OXFORDSHIRE COUNTY COUNCIL'S RESPONSE TO CONSULTATION ON THE FOLLOWING DEVELOPMENT PROPOSAL

Application no: 23/00390/F

Proposal: The erection of an industrial Rubb storage building, extension of the existing industrial building to create a new visitor reception, external alterations to elevations, reconfiguration of the existing open service yard and car park, provision of photovoltaic (PV) panels on roof and associated landscaping and works.

Lead Local Flood Authority

APPENDIX H

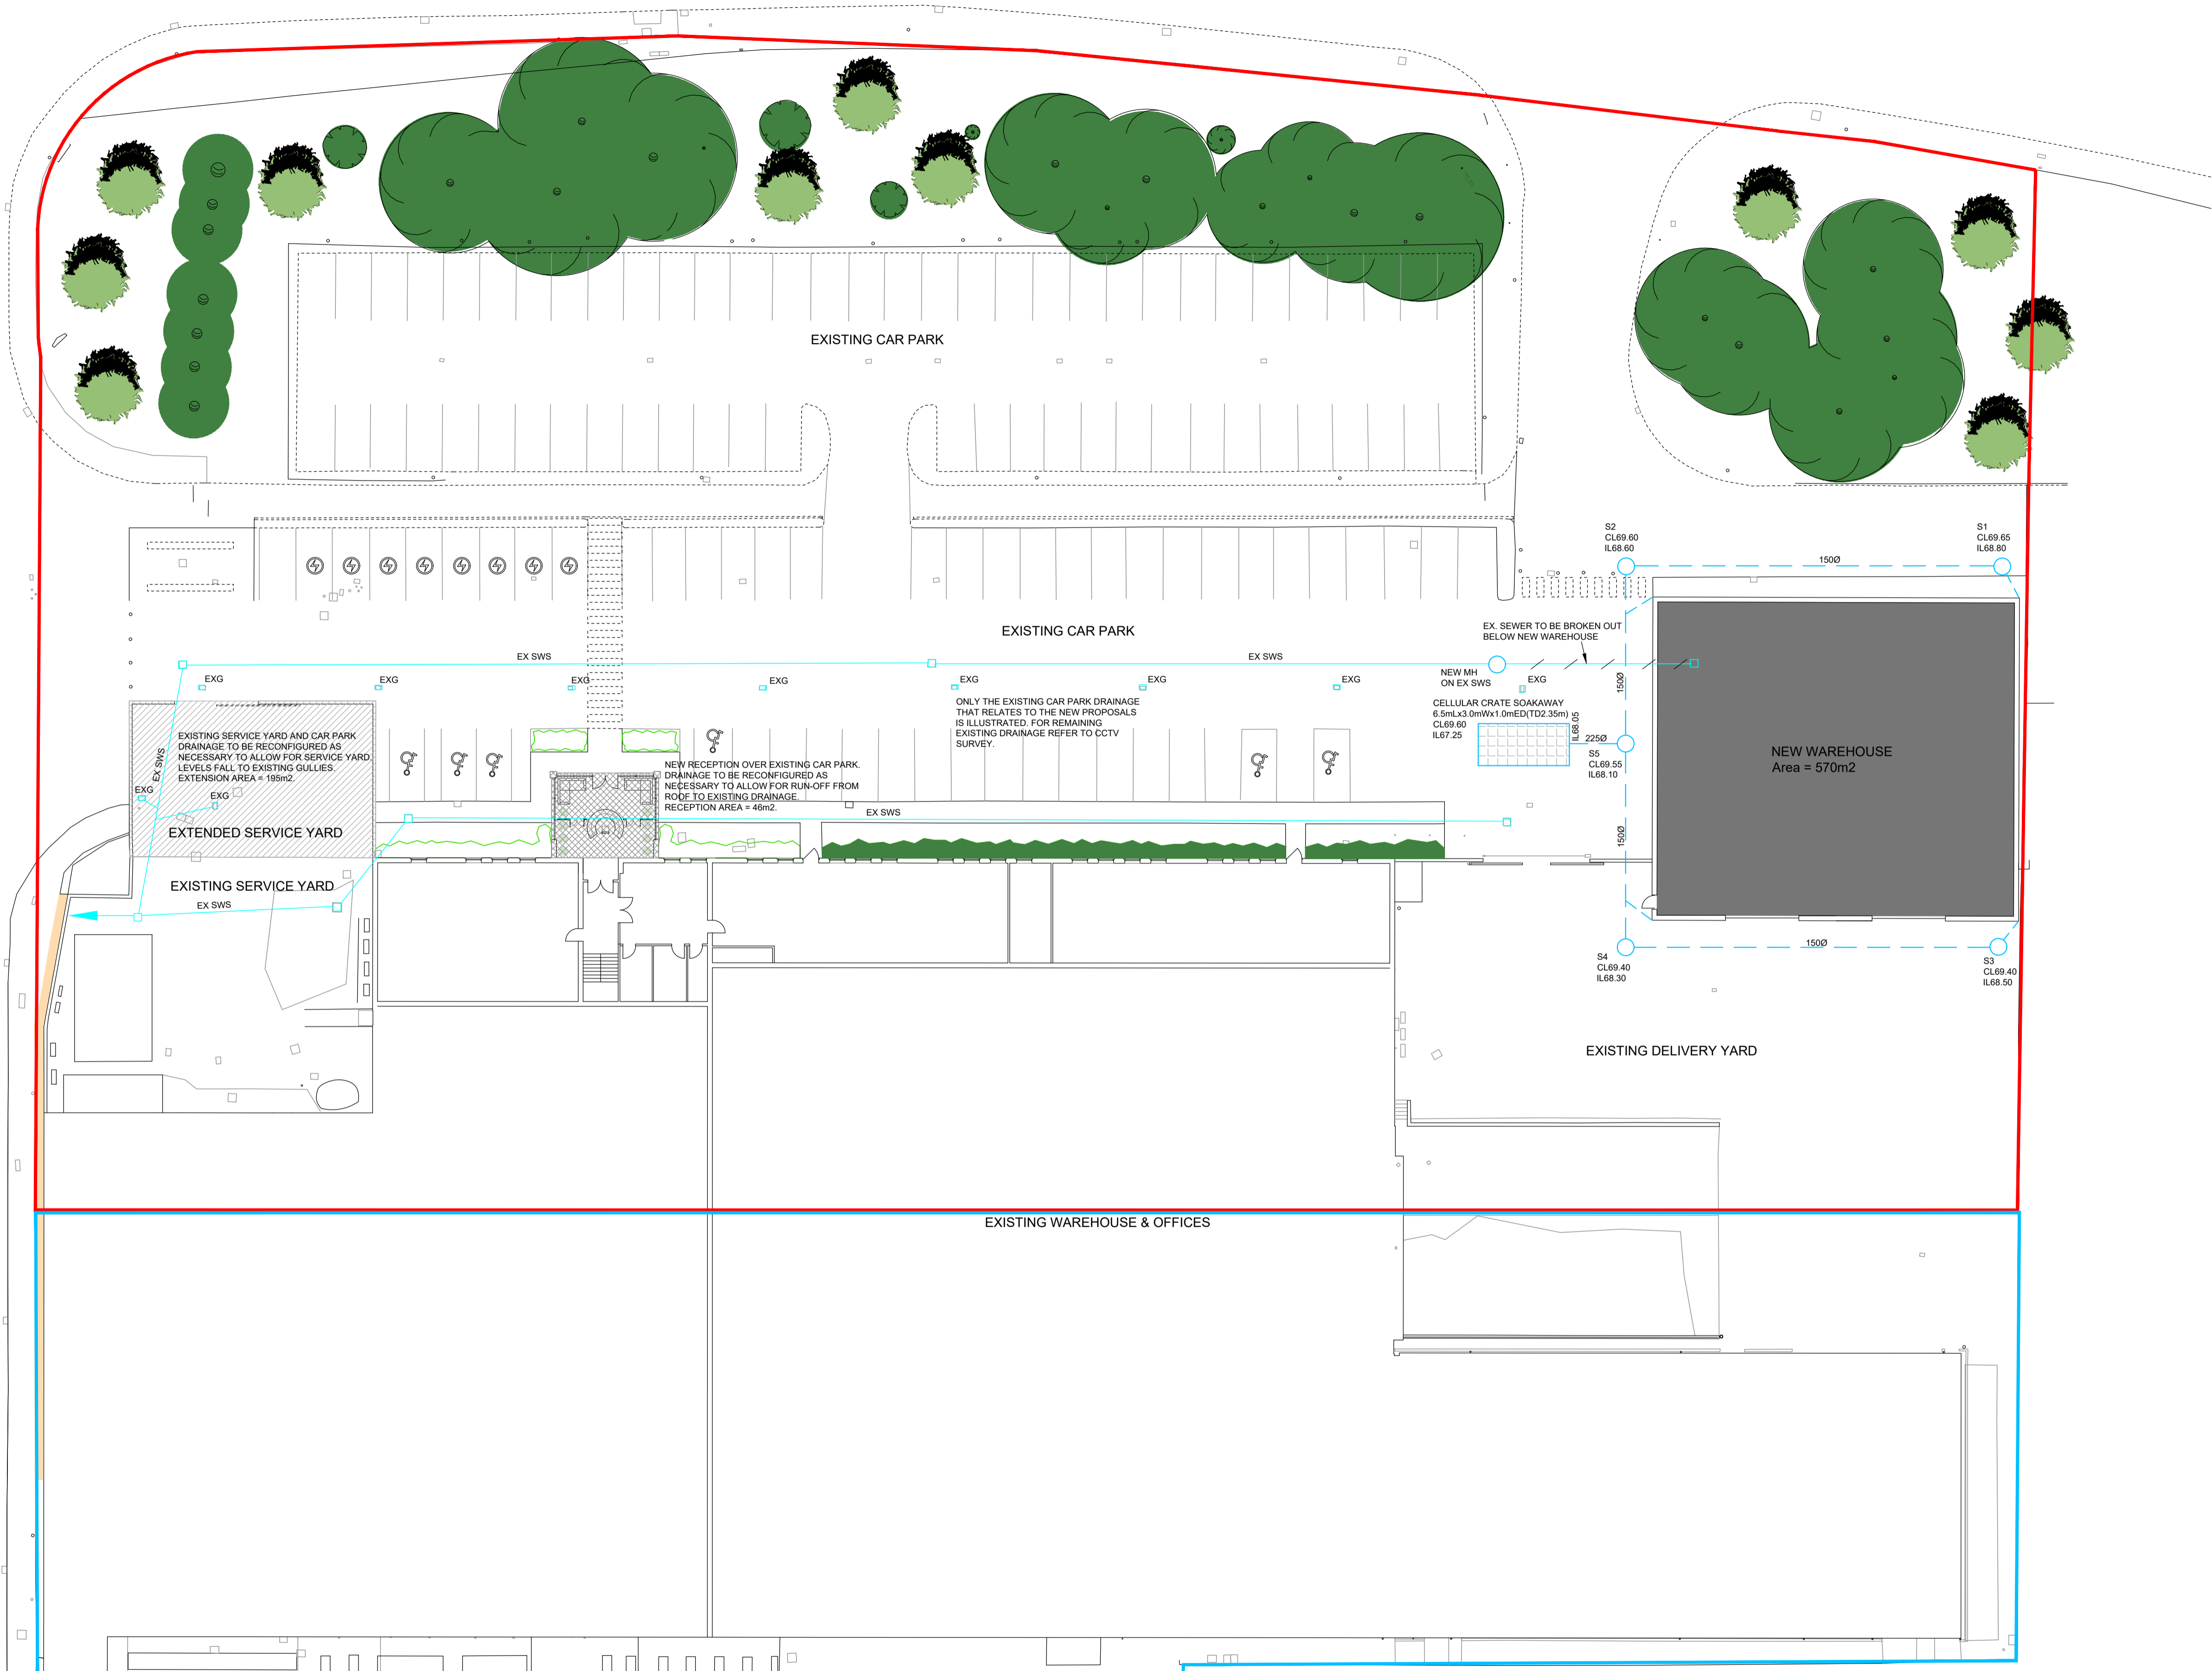
The LLFA is happy with the overall strategy however, detailed drawings needs to be provided in order to lift the objection. The drainage drawing states preliminary design. The LLFA requires the final detailed design drawing. Also, on the drawings the pipe gradients needs to be shown for the proposed drainage strategy. Manhole size and invert/cover to be shown for the new manhole.
